City of Albuquerque Stormwater Construction Site Inspection Report

Project Name and Location	Family Dollar 1400 Gibson SE		
Site Contact Name & Agency	Bret Blanchard	ESC File No. NPDES ID No.	L15E049
Date of Inspection	11/02/2018	Start/End Time	10:30am 11:15am
COA Inspector Name	Cassandra Durkin, Stormwater Quality		
Describe Present Phase of Construction	Landscaping

FAMILY DOLLAR STORE
EROSION & SEDIMENT CONTROL PLAN

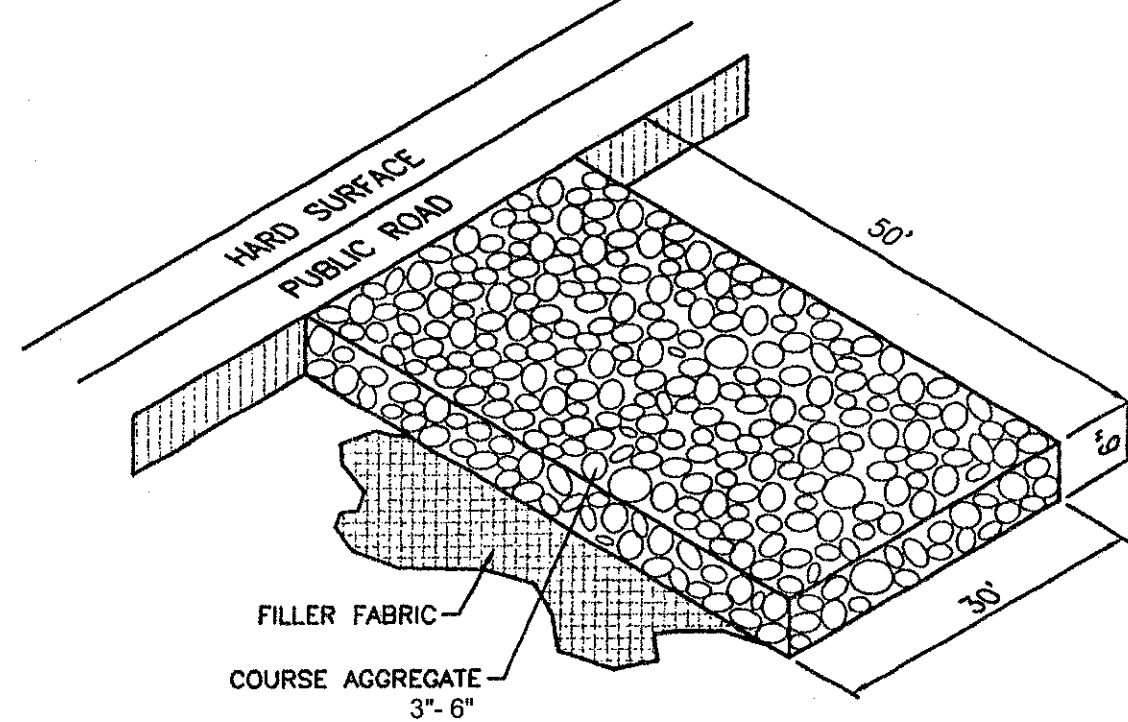
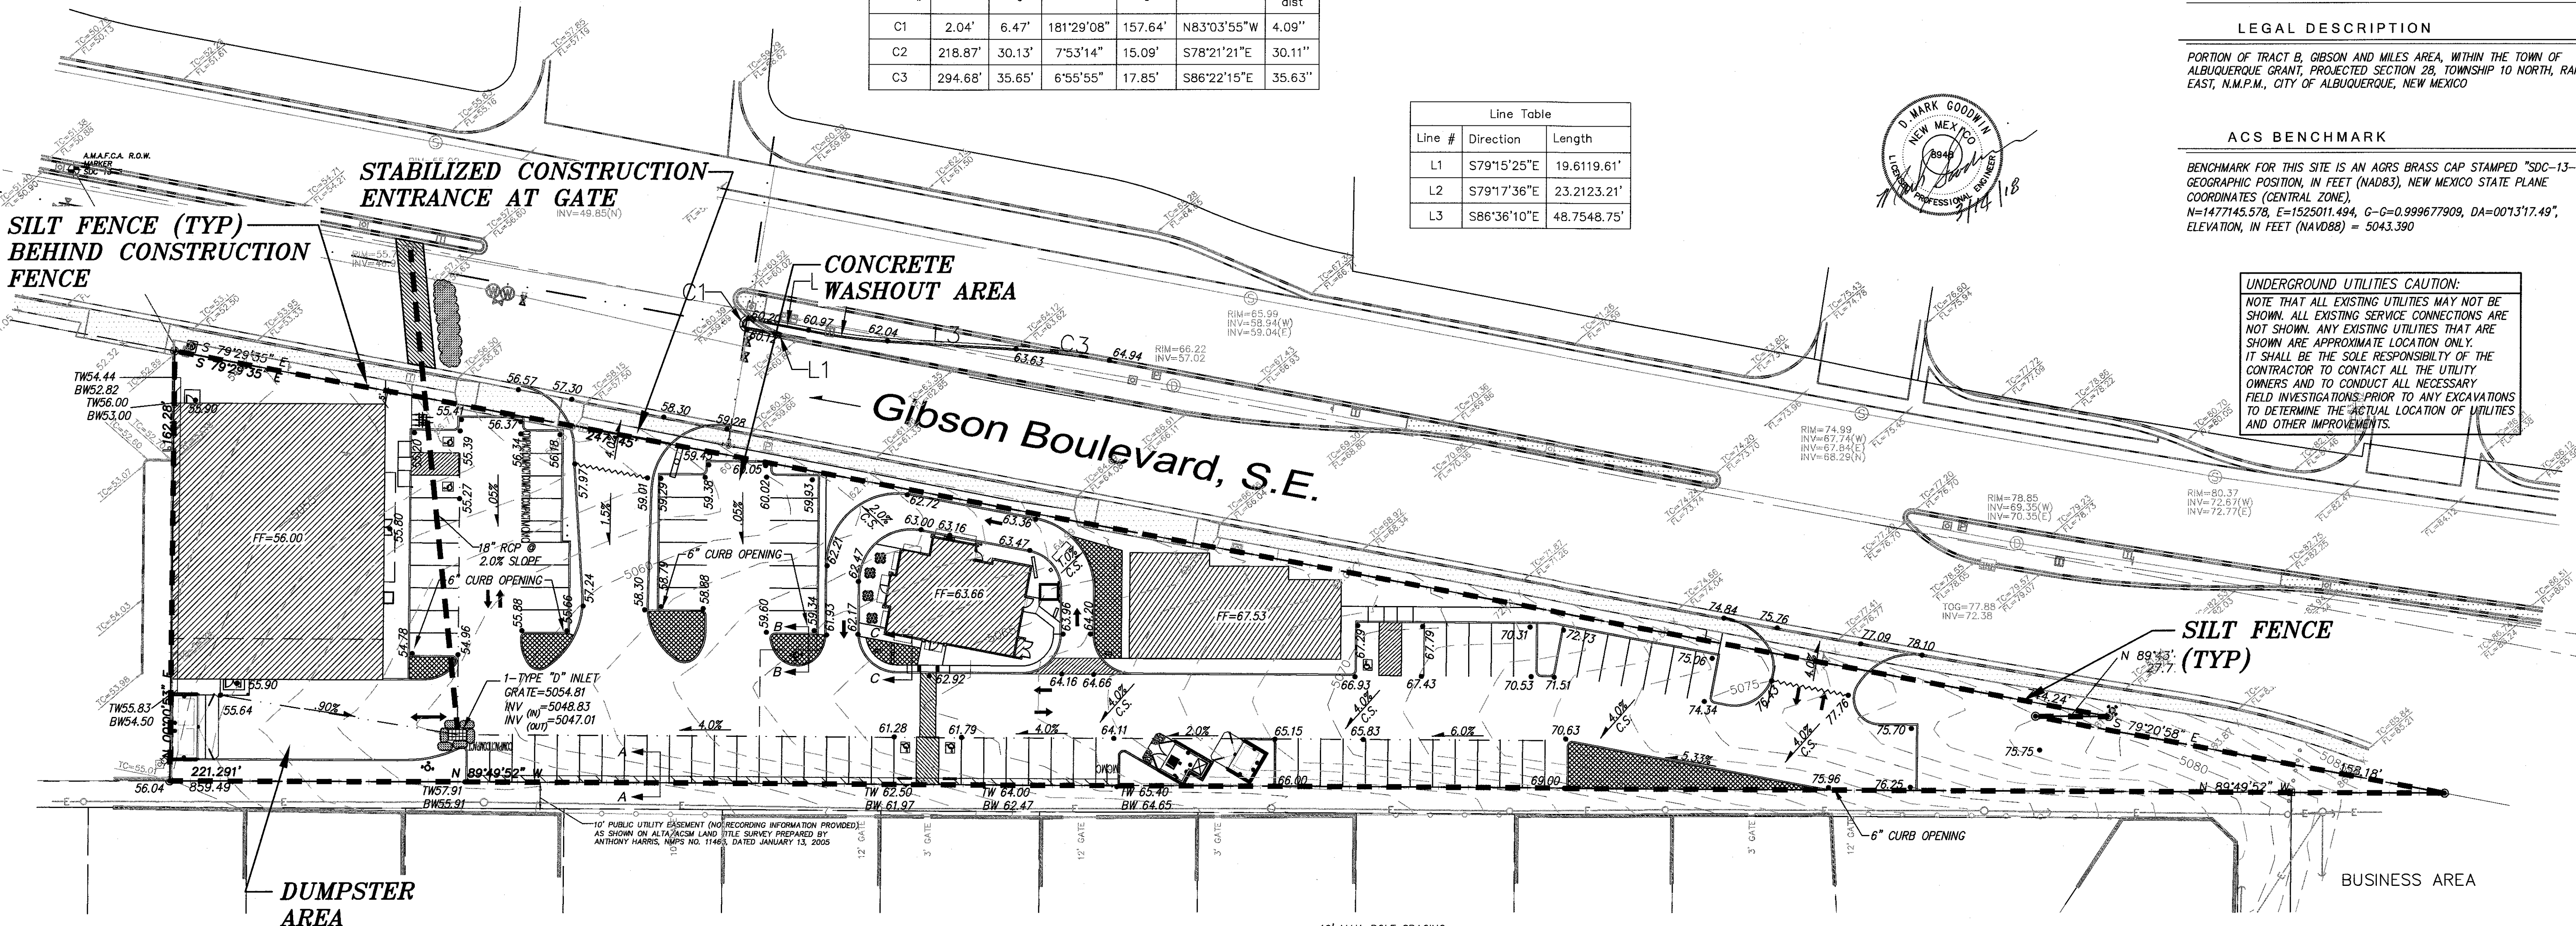
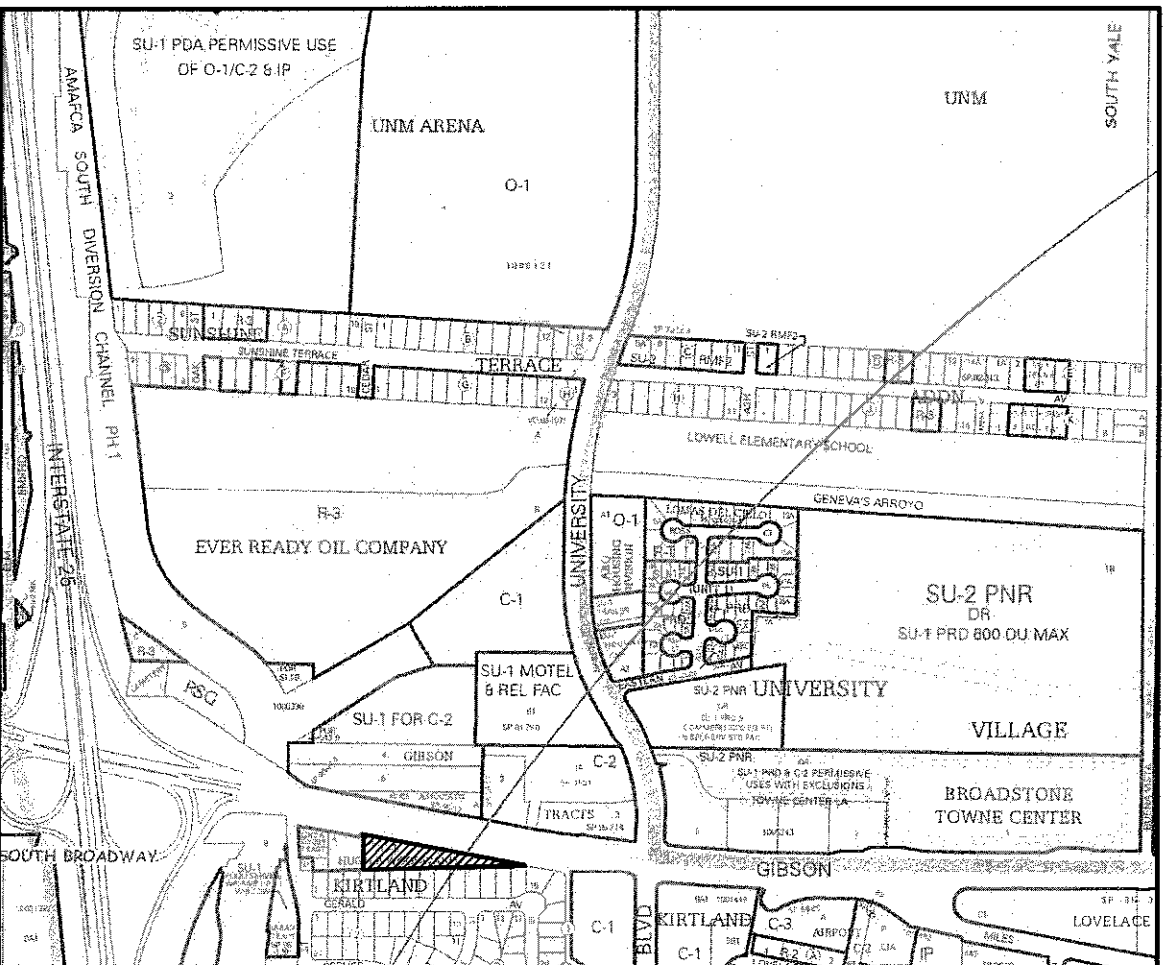
CGP	BMP / Activity	Maintenance Required? (1)	Corrective Action Required? (2)	Location and Notes
1.5	Post a Notice			
2.2.1	Provide and maintain Natural buffer when Waters of the US < 50 ft			
2.2.3	Sediment control along any perimeter		Yes	Silt Fence Required at SW Corner
2.2.3	Sediment control along any perimeter	Yes		Maintain Sediment BMP at NW Corner, remove dirt from street
2.2.3	Sediment control along any perimeter			
2.2.3	Sediment control along any perimeter			
2.2.3	Sediment control along any perimeter			
2.2.3	Sediment control along any perimeter			
2.2.3	Sediment control along any perimeter			
2.2.4	Minimize sediment track-out			
2.2.5	Manage stockpiles

2.2.6	Minimize Dust			
2.2.10	Protect Storm Drain Inlets	Yes		Maintain Inlet Protection SE of Building
2.2.10	Protect Storm Drain Inlets			
2.2.11	Minimize erosion of conveyance channels		Yes	Roof Drains are causing erosion

2.3.3	Fuel, oil, hydraulic fluid, petroleum products and chemical storage			
2.3.3	Construction and Domestic Wastes	Yes		Debris, Litter, and Dirt piled against alley wall.

2.3.3	Construction and Domestic Wastes		Yes	Waste Container required
2.3.4	Washing Applicators used for paint, stucco, concrete, etc.	Yes		Remove mortar washout from SW Corner of site.

Please correct maintenance items of by the end of day 11/05/18. Corrective action must be completed within seven days.
